### ADDENDUM 3

**SUBJECT: Gladstone and Loretta Redevelopment Review of Proposed Changes**

Ownership at the CLV Group wish to pursue changes to the planned redevelopment at Gladstone and Loretta Avenue. These changes include a revised phasing of work, with a new architectural team focusing on the first phase — Tower A (formerly Tower 3), and additional height for all 3 towers. The conservation of the Standard Bread Building, a designated historic building, continues to be a feature part of this redevelopment. The attached site plan illustrates the site layout, and the positioning and massing of the three towers. All three towers will be taller with the addition of typical floors.

WEST SITE ELEVATION -
PHASE 2 MASSING

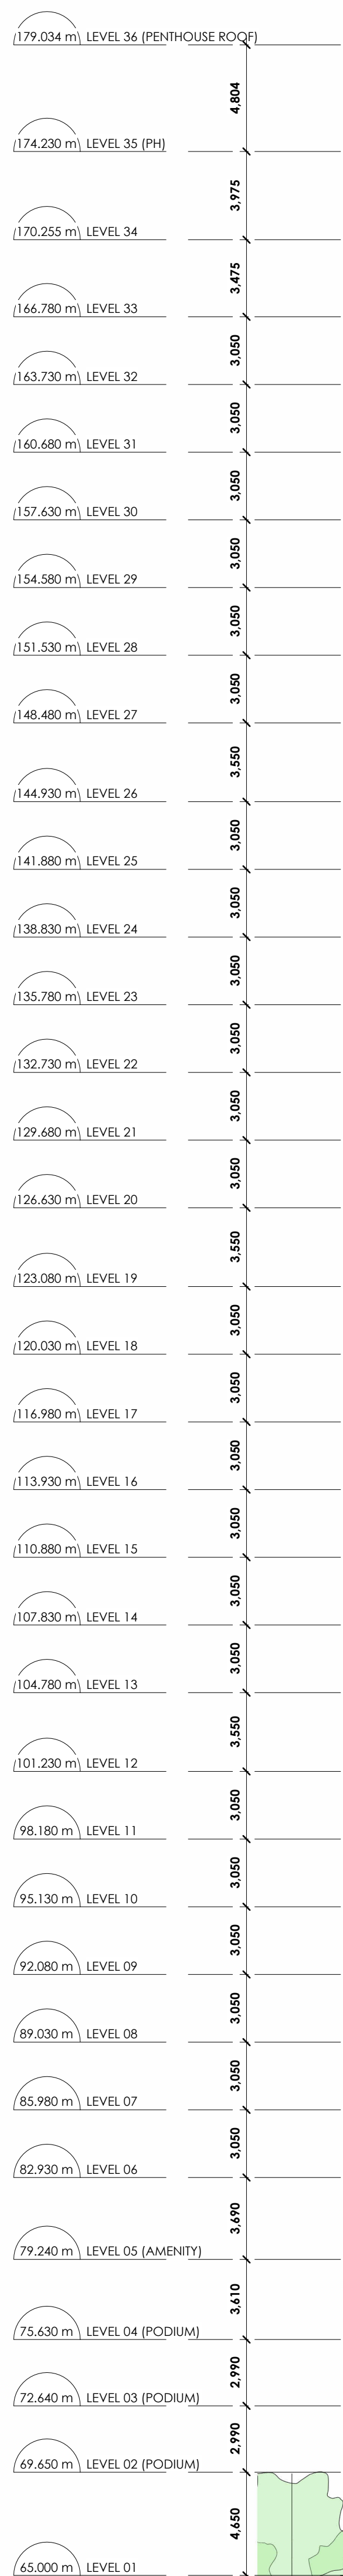
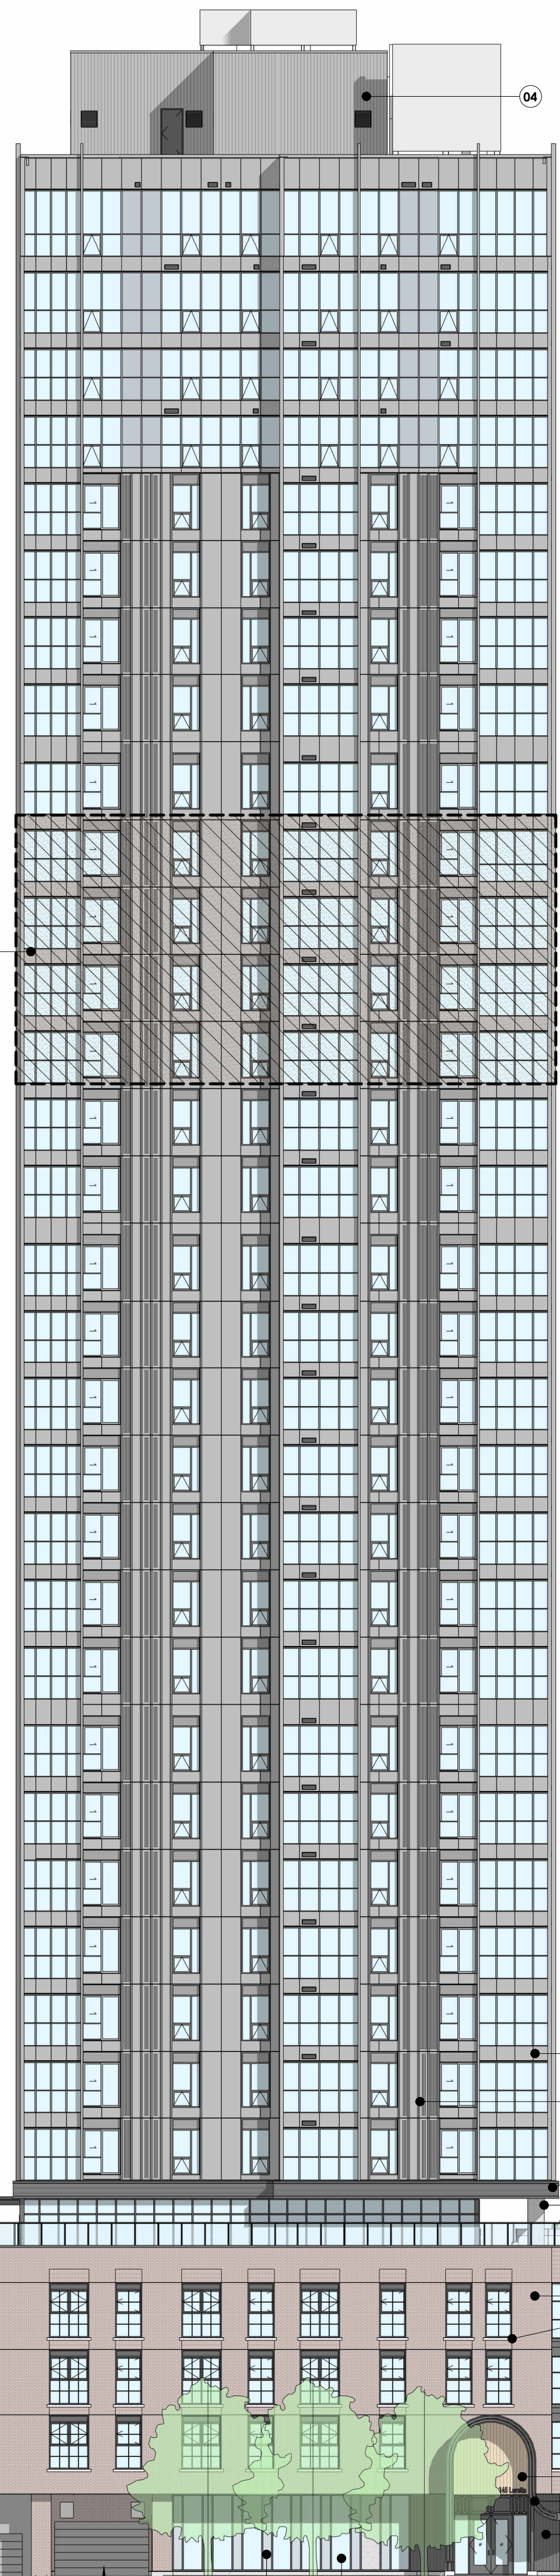
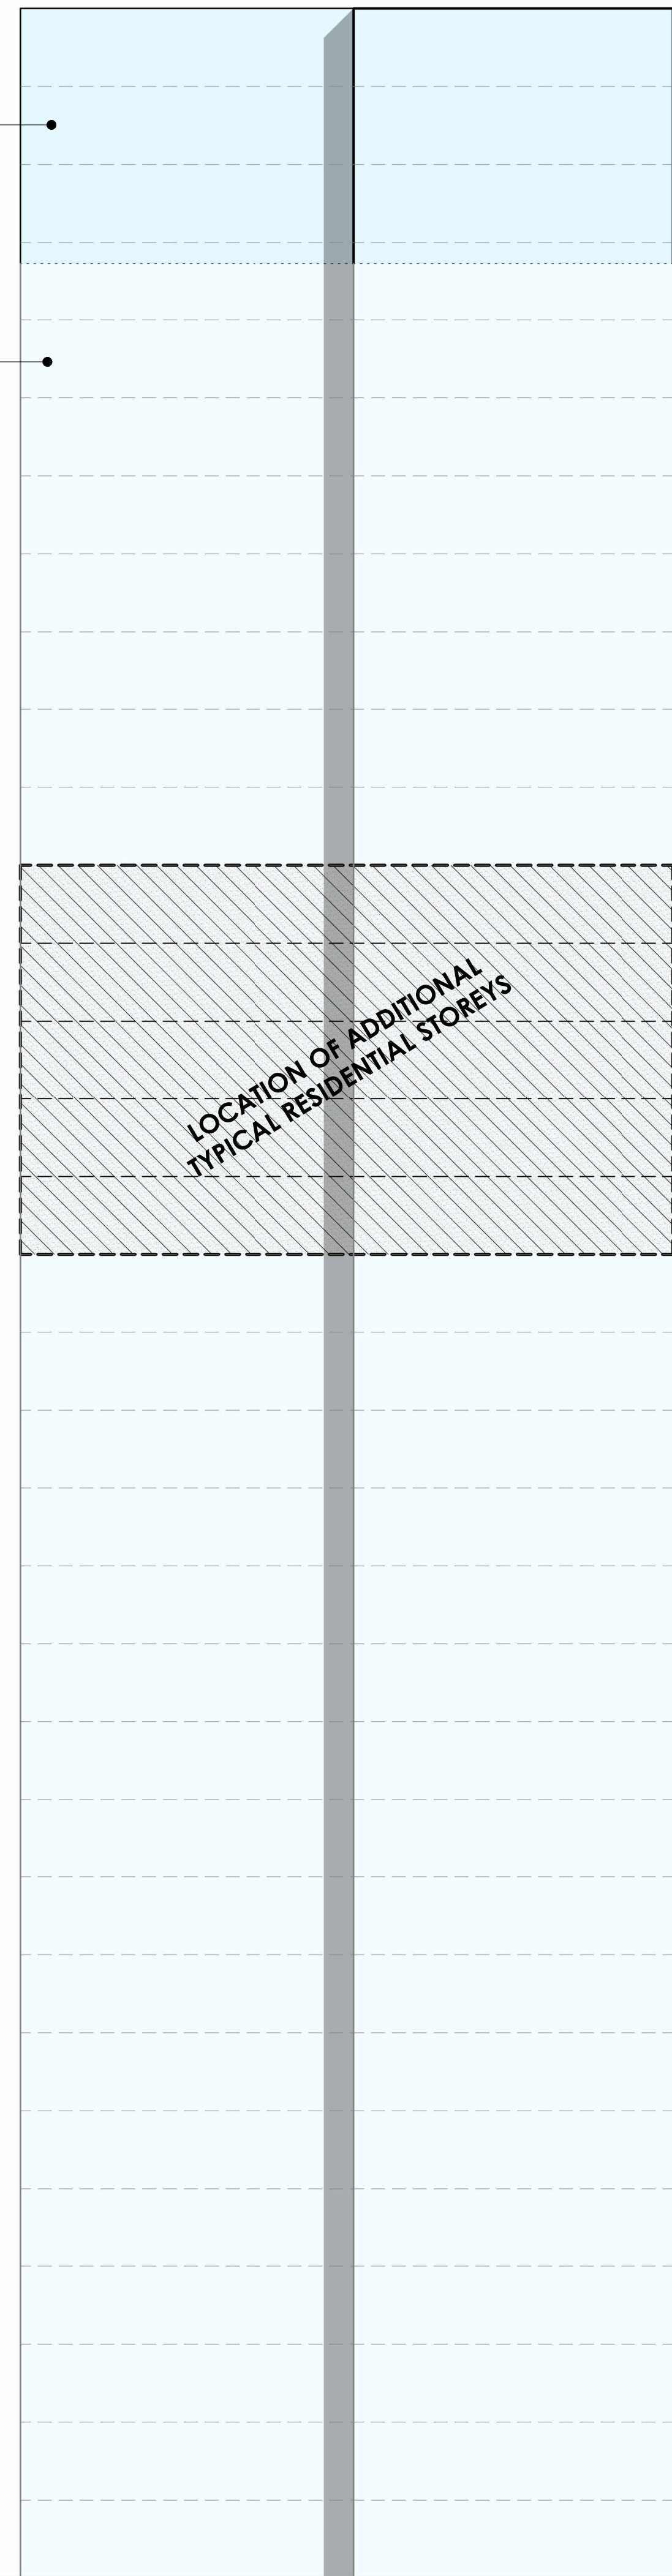
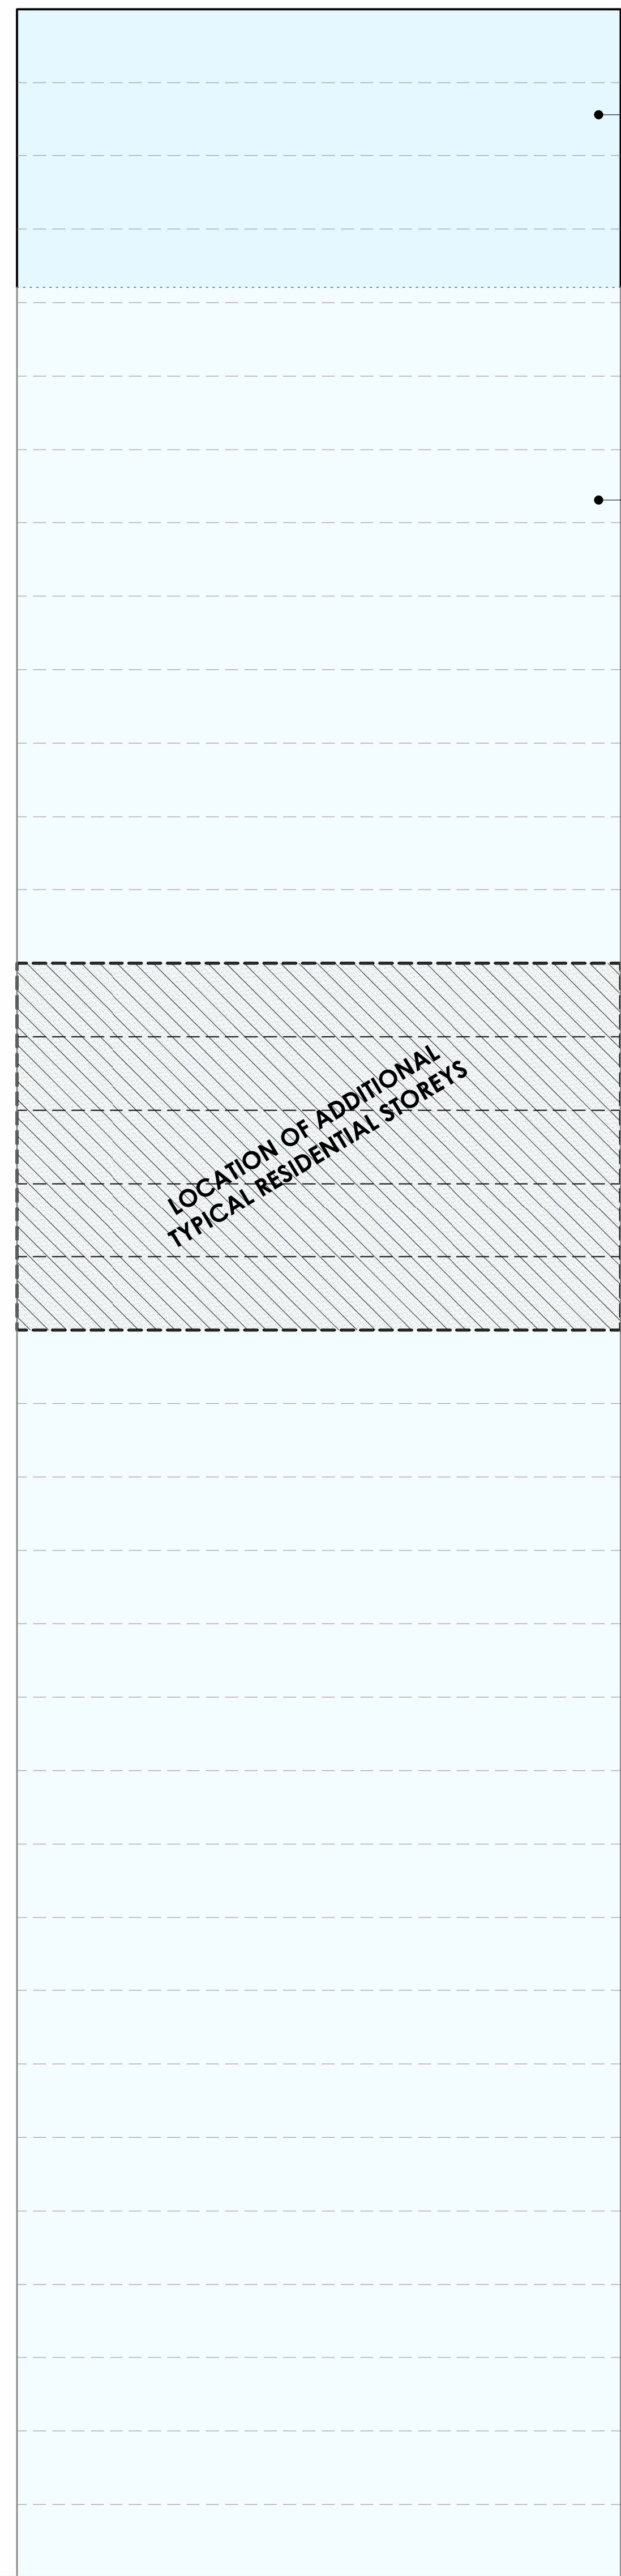
- *The building's landmark status in the neighbourhood for its location at the top of a small hill adjacent to the railway tracks is maintained.*
- *Given that the Standard Bread Building is positioned at the southeast corner of the site, there should not be any adverse shading impact from the increased height of the towers.*

- *The proposed massing of the three towers respects the Standard Bread Building and reflects a pedestrian-scale along the street. The three proposed high-rise towers are set well back from the adjacent streets to acknowledge this scale and character.*

- *Along Gladstone, the podium height, and exterior finishes respect the height of the heritage building.*
- *On the west side of the building, the link between the new development and Standard Bread Building.*
